Application No: K/55/20/PL
Site Address: 57 Coastal Road Kingston BN16 1SN
Description of works: Demolition & erection of 1 No. dwelling. This application is in CIL Zone 4 and is CIL Liable as new dwelling.

Thank you for your internet representation made on 22nd January 2021 which has been recorded as an objection with the comments as follows:

Roof plan

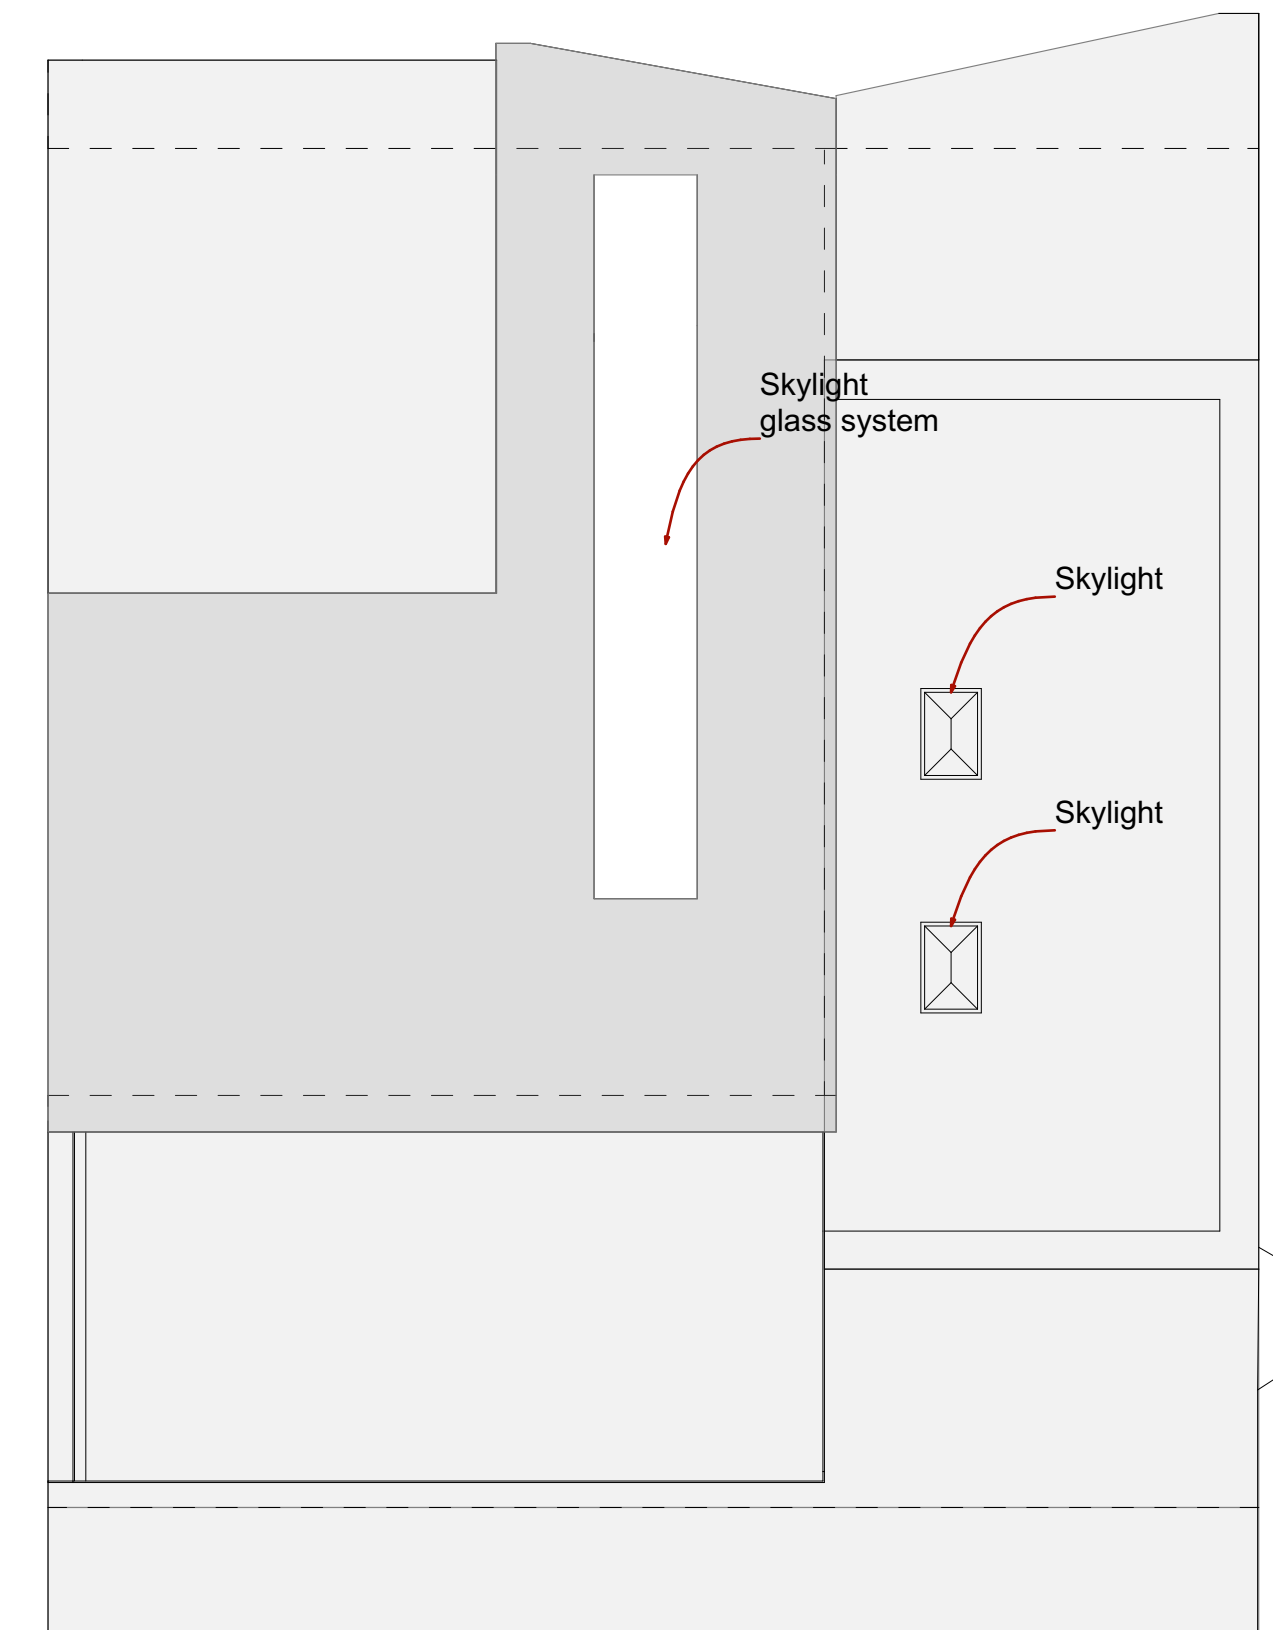
The proposed plans and elevations dated 19.11.2020 also incorrectly reference the east and west elevations and the Design and Access Statement incorrectly refers to detail associated with new first floor windows proposed on the new dwelling which will directly overlook no. 59 Coastal Road. Paragraph 4.3 states 'There would be two clear-glazed side facing windows on the western elevation facing toward no. 59. Side elevation appears to contain 2 windows, 1 serving a small bedroom and 2 side secondary windows serving the master

bedroom'. This is totally incorrect. The first floor layout drawings actually show a proposal to introduce four habitable room windows in the western side elevation which will overlook no. 59, as well as a proposed bathroom window. It should be noted that no. 59 has three habitable room windows in its side elevation at ground level facing the application site. Indeed the first section of paragraph 4.3 recognises that first floor windows are likely to give rise to overlooking and this is proposed to be addressed by these relating to en-suites 'which will be conditioned and proposed to be obscure glazed to protect the privacy of existing neighbouring residents and future occupants of the property.' However, as stated above, these are not solely serving en-suite facilities.

The Applicants' details also indicate that the second floor will be recessed in the site away from the current footprint but it is unclear from the layout drawing and elevations how this is achieved. The introduction of the extensive depth of development at first floor and the addition of the second floor creates an oppressive built form right up close to the western boundary, creating a sense of enclosure, overshadowing and loss of sunlight to the neighbouring property having regard to orientation and where receipt of morning sunlight in particular to no. 59 will be impacted. No sunlight/daylight assessments have been included to demonstrate otherwise.

For ST Charles Homes LTD	
Drawing Proposed Site Layout & Landscaping, Street Scene, Parking plan	
Project La Casa, 57 Coastal Road, West Kingston East Preston BN16 1SN	
Scale	1:200 on A1
Date	19.11.2020
Made by Arch. Grygorieva A.A.

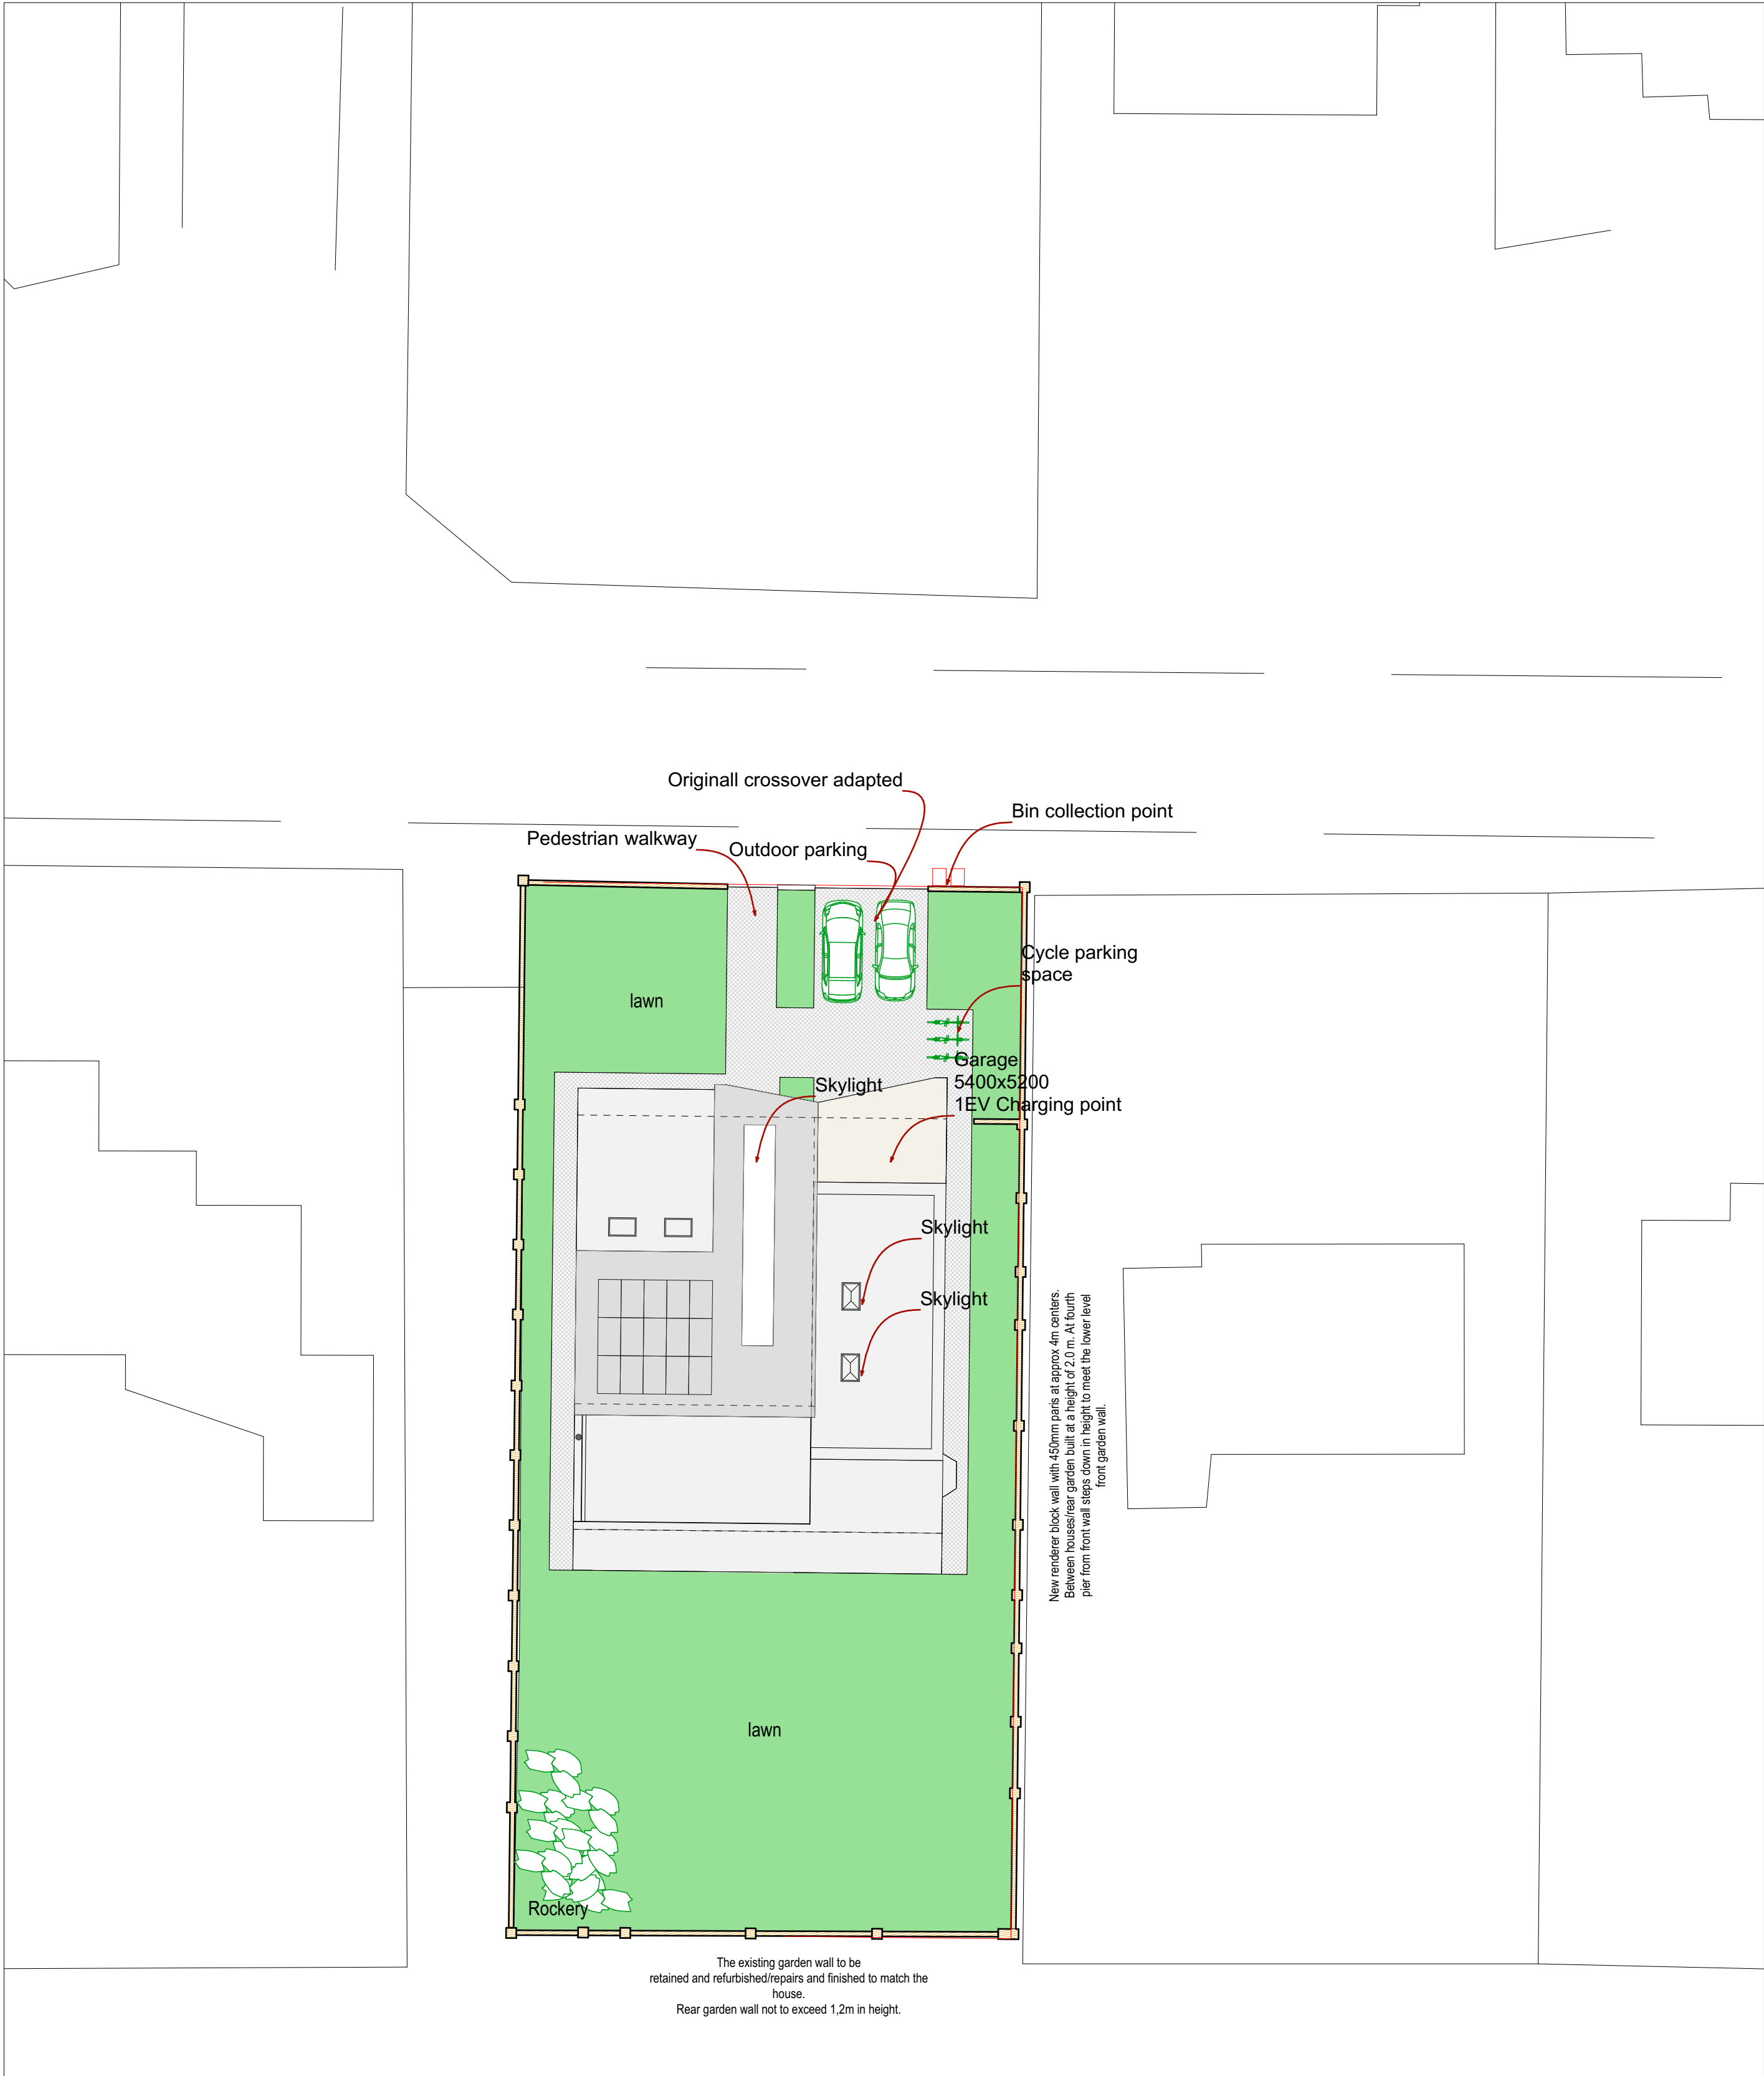
I note that there are a number of errors shown on the drawings which results in the presentation of misleading information. The proposals cannot be determined on such inaccuracies. For example, it is noted that on 'Proposed Site Layout and Landscaping, Street Scene, Parking plan' dated 19.11.20 (lacking a scale bar) the siting of the proposed new dwelling is shown to extend beyond the rear building line of the neighbouring dwellings. This in itself is unacceptable, but more so when the details do not accord with the coloured location plan on the site plan, location plan and section AA dated 15.06.2020 which clearly shows a different development extending even further to the south with limited rear garden. This layout also shows a completely different form of development with skylights shown on the western side which do not relate to the other layout drawings. The perspectives shown on page 3 of the Design and Access Statement do not reflect the elevation drawing details with different set-backs shown, which I believe is further misleading.
